From: White, Joy - E&E [<mailto:Joy.White@Oxfordshire.gov.uk>]
Sent: 12 April 2018 16:01
To: Caroline Ford
Subject: 18/00080/DISC

Site: **ELMSBROOK, BICESTER**
Address: **PHASE 3 & 4**
Dwg Title: **SITE LAYOUT**
Scale: 1:500
Page Size: A1
Date: OCT 17
Drawn: DC
Checked: MD
Drawing No: **14790TA-3202**
Revision: **T6**

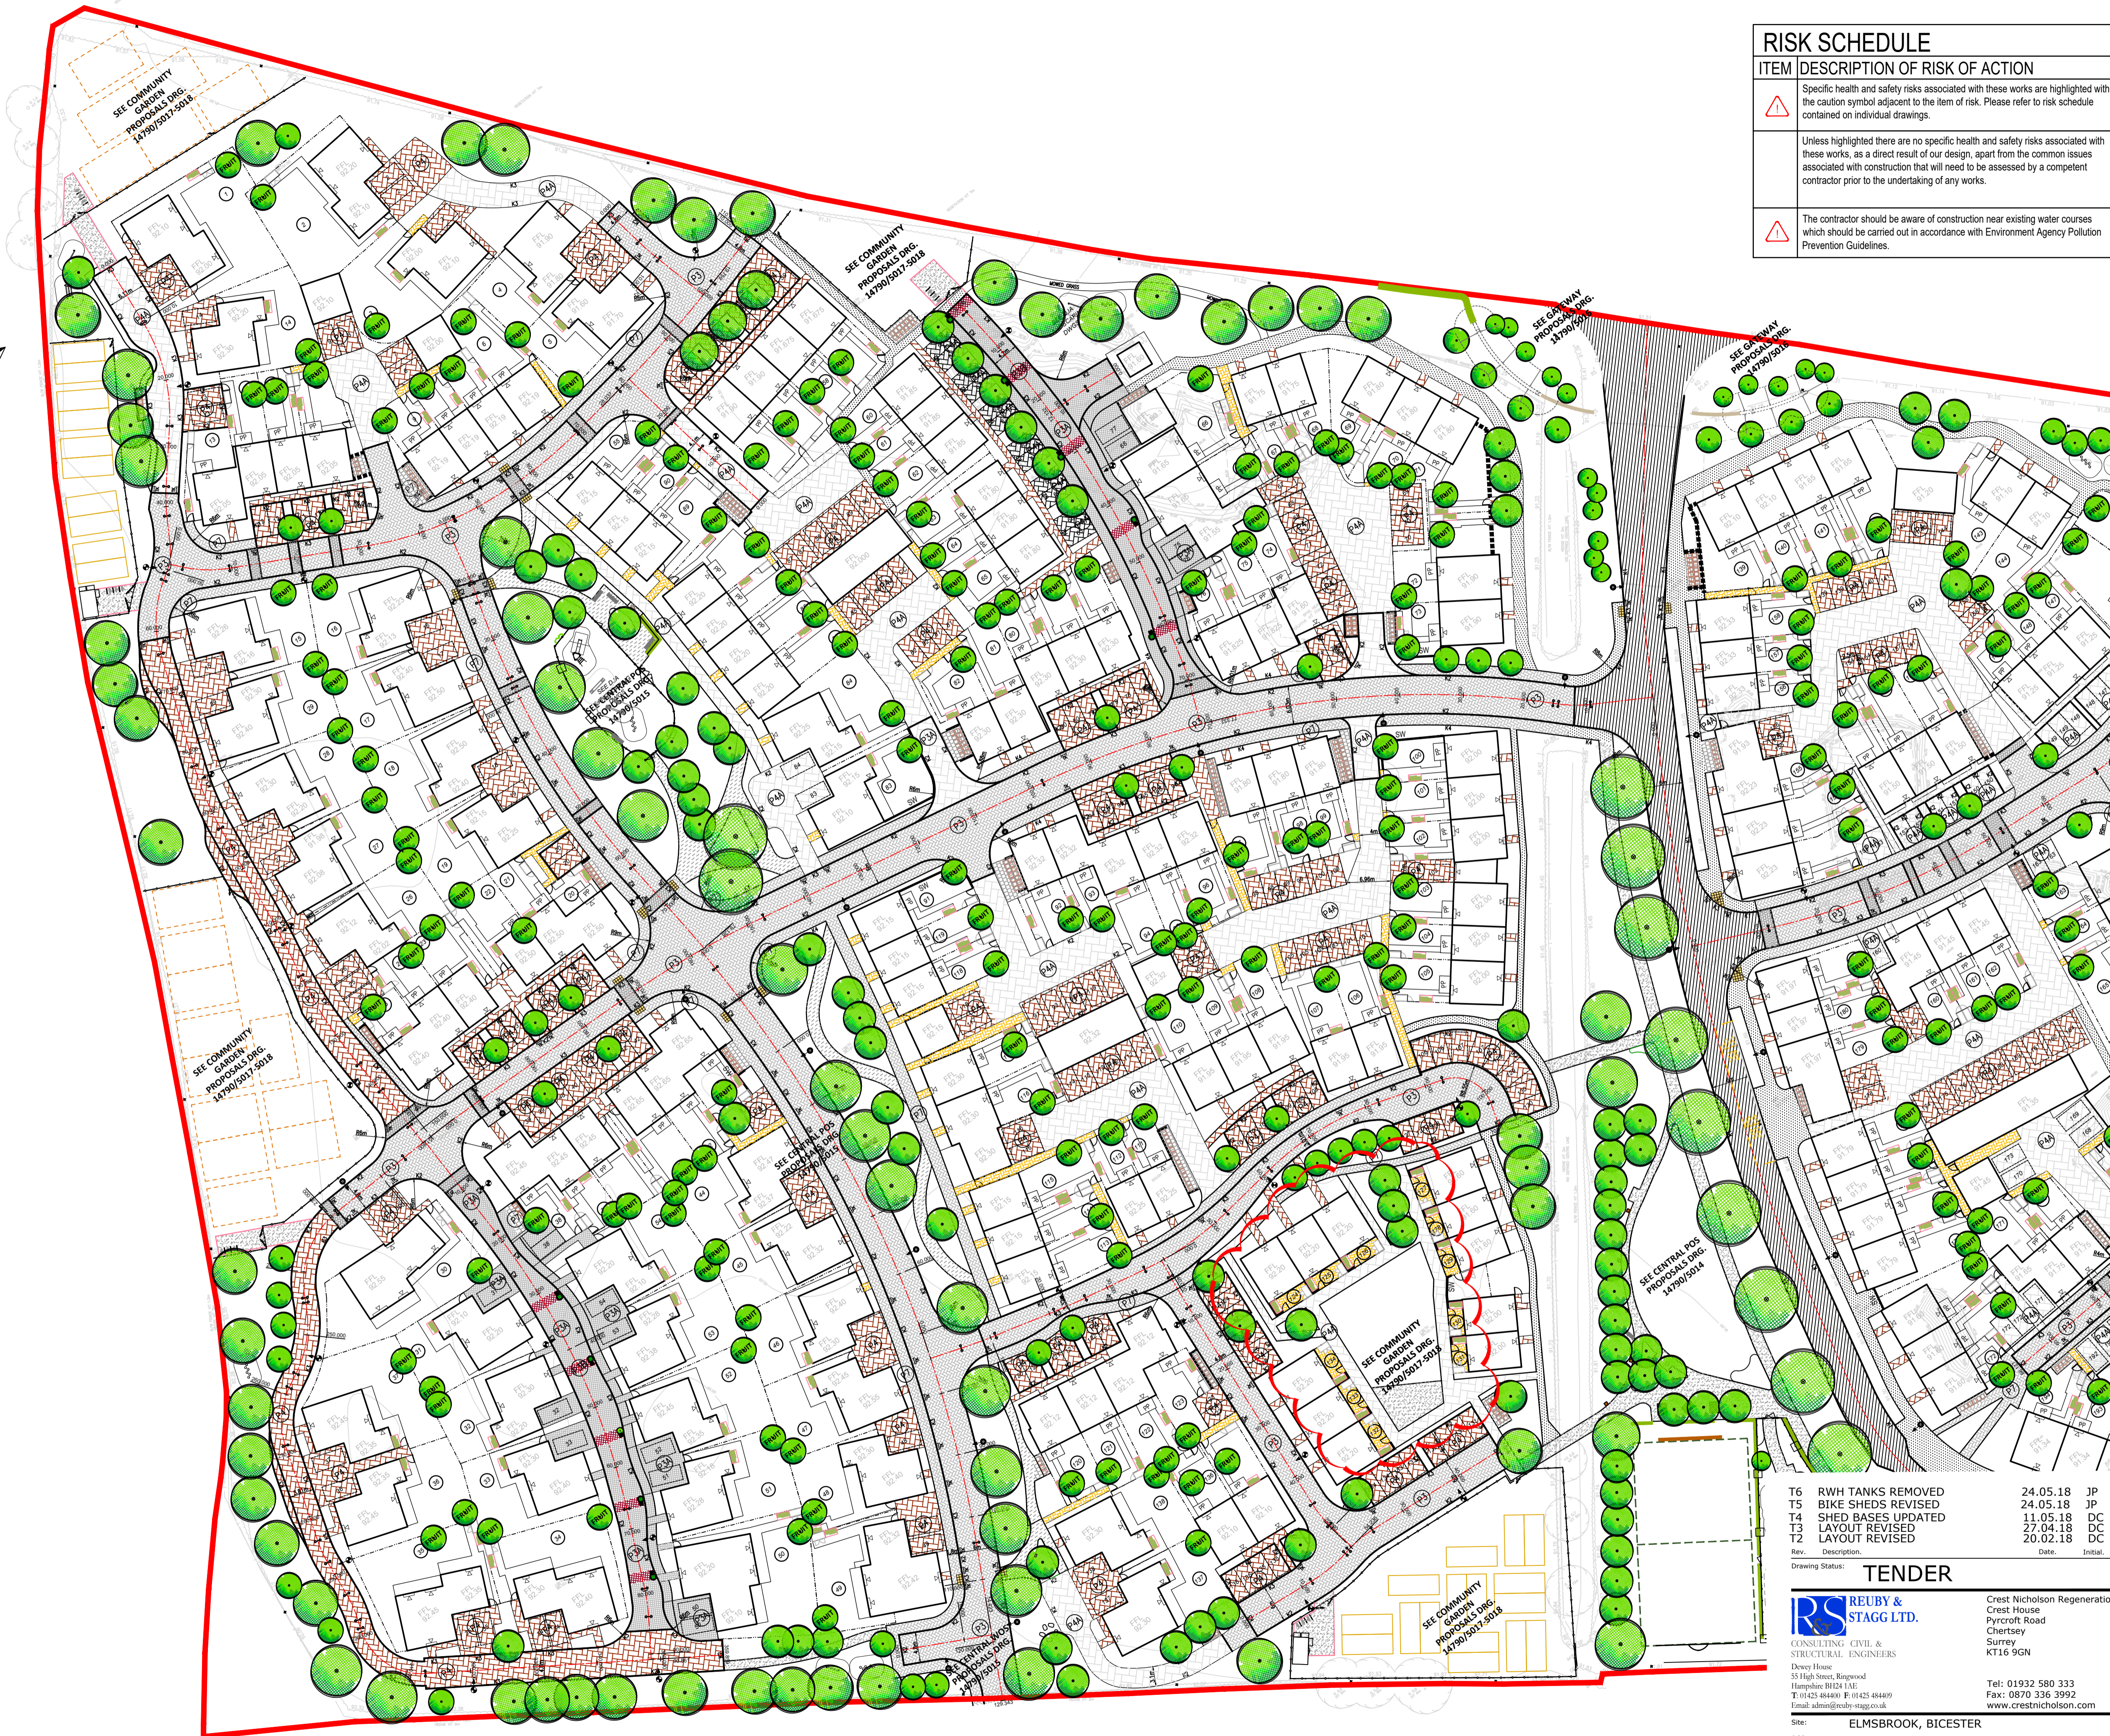
The layout is not 100% clear, but it seems there is proposed one of the cycle lockers for each property that does not have a garage. The cycle lockers look fine. I assume these are the double door red 'cupboards' on the layout plan. If this is the case, then I have no objection to the discharge of condition 13.
